1 July 2022
Our Ref: 20728C.3TW_S4.55(1A)

**RE: SECTION 4.55(1A) APPLICATION TO MODIFY
DEVELOPMENT CONSENT NO. SSD-10379
SUTHERLAND ENTERTAINMENT CENTRE**

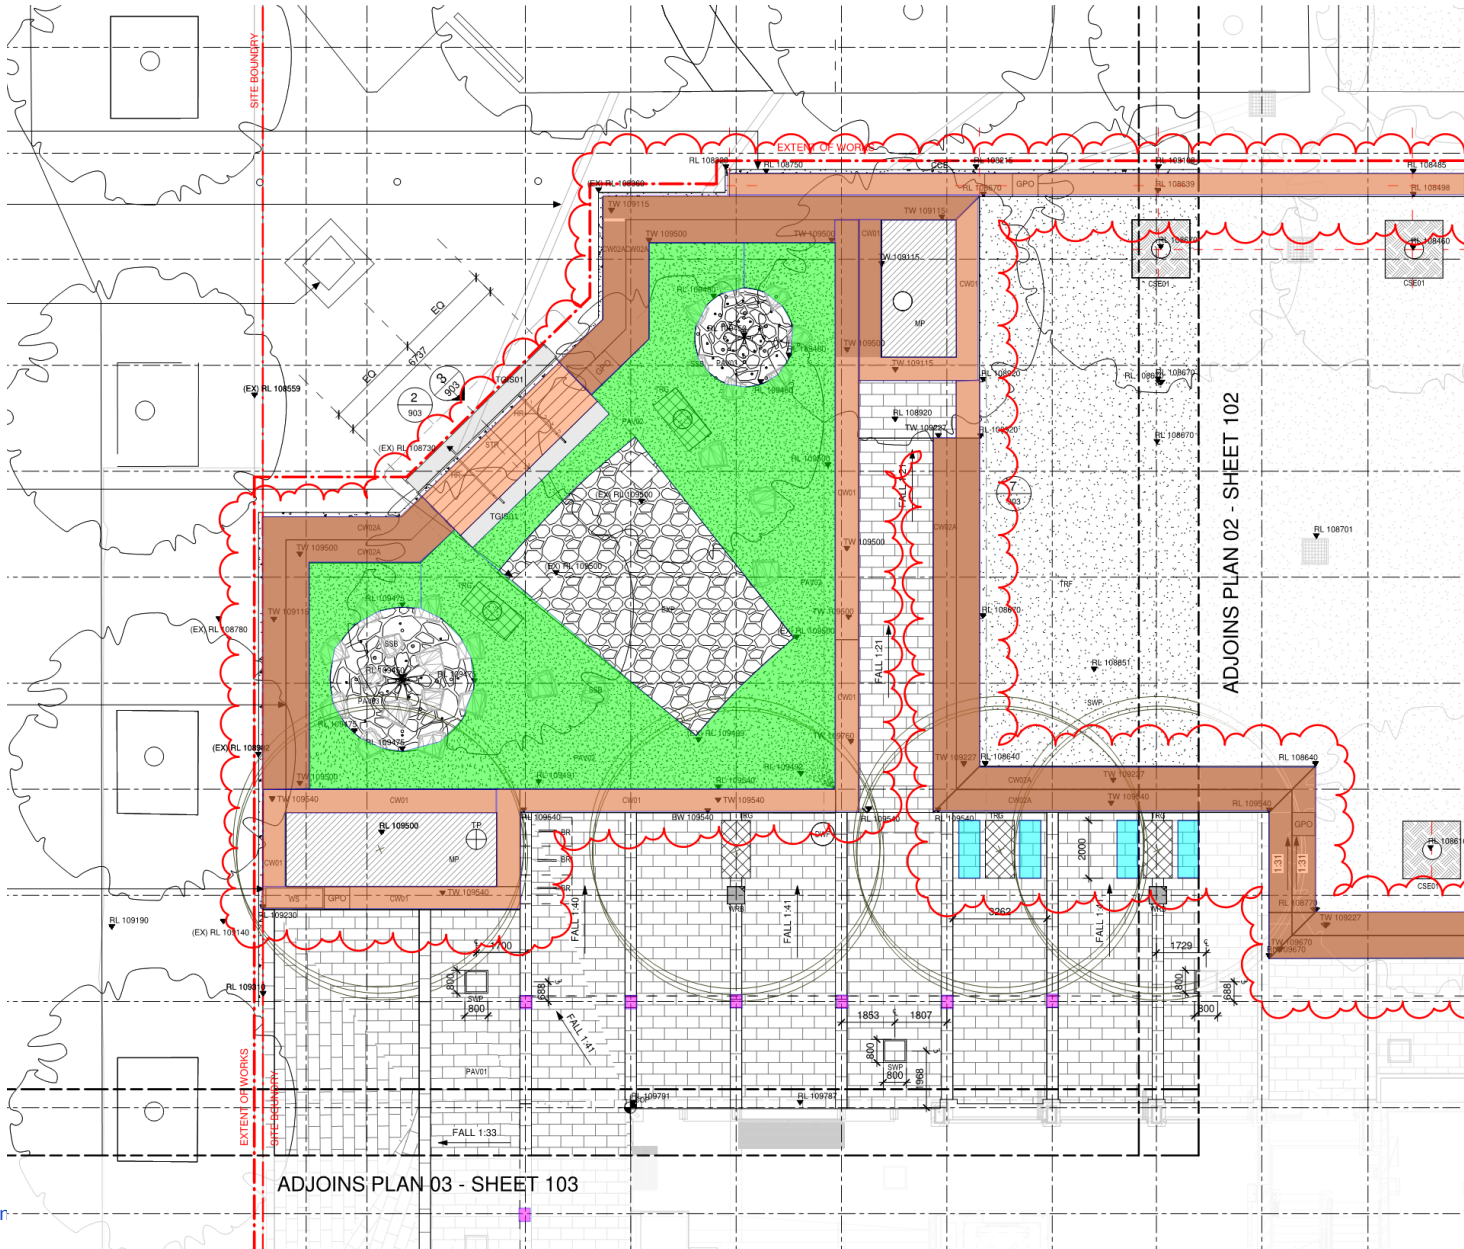
Modifications are proposed to the colour of the concrete of approved elements of the landscaping. As provided on the plans prepared by ADCO, the changes in concrete colour include the approved external retaining walls, hobs, bleacher seating and stairs. The concrete colour for these areas, identified on the plans prepared by ADCO is proposed to change from an off-white colour and will be replaced by a standard grey.

It is noted that all of the above elements have been approved with a non-standard grey concrete colour. The proposed modifications to the concrete colour are minor and the need for the change predominantly arises from maintainability and repair concerns that have been raised by Council.
